From: Simon Davis
Sent: 24 December 2018 11:59
To: 'Dawn Appleton' [REDACTED]
Subject: RE: AW/198/18/PL

DRAWING TITLE
Proposed Plans and Elevations

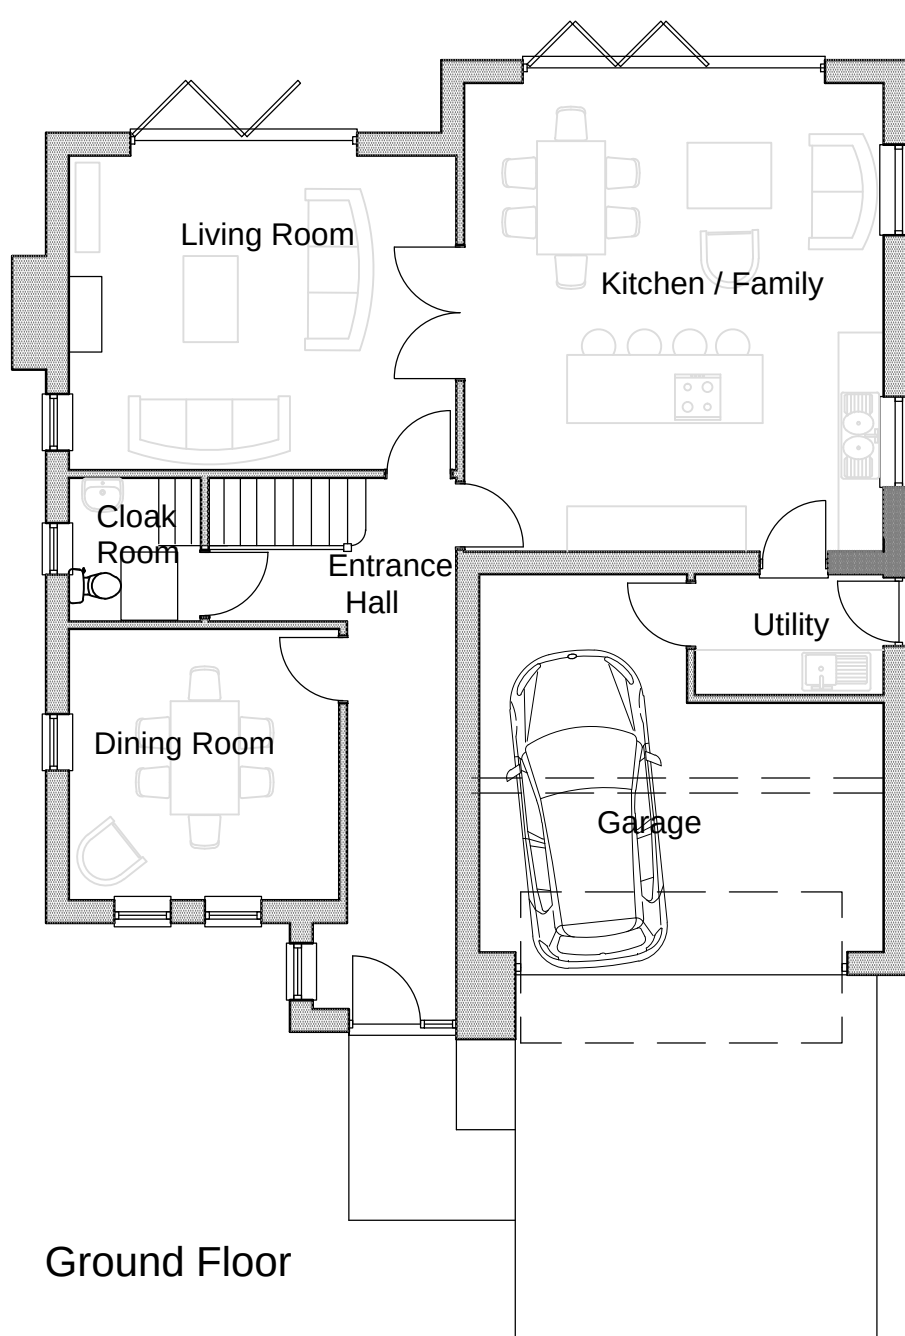
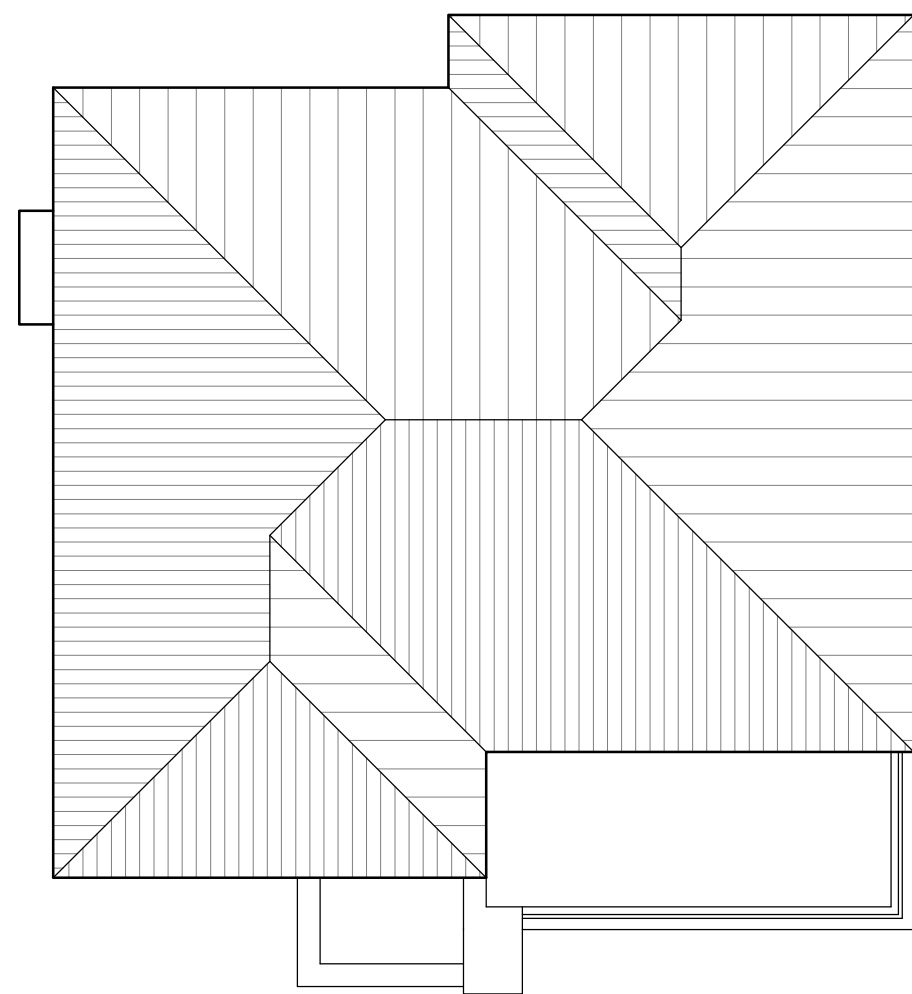
I have had a look again at the application this morning. I am not prepared to comment to the acceptability of the proposal in an email but I am happy to discuss over the phone. However, I would request one small change to the design of the house – I would like to see a privacy screen to the SE side of the front balcony. This should preferably be in the form of an 'extension' of the flank wall upwards to a height of 1.7m above the balcony ground level. However, as an alternative I would accept a non-reflective obscured glass screen.
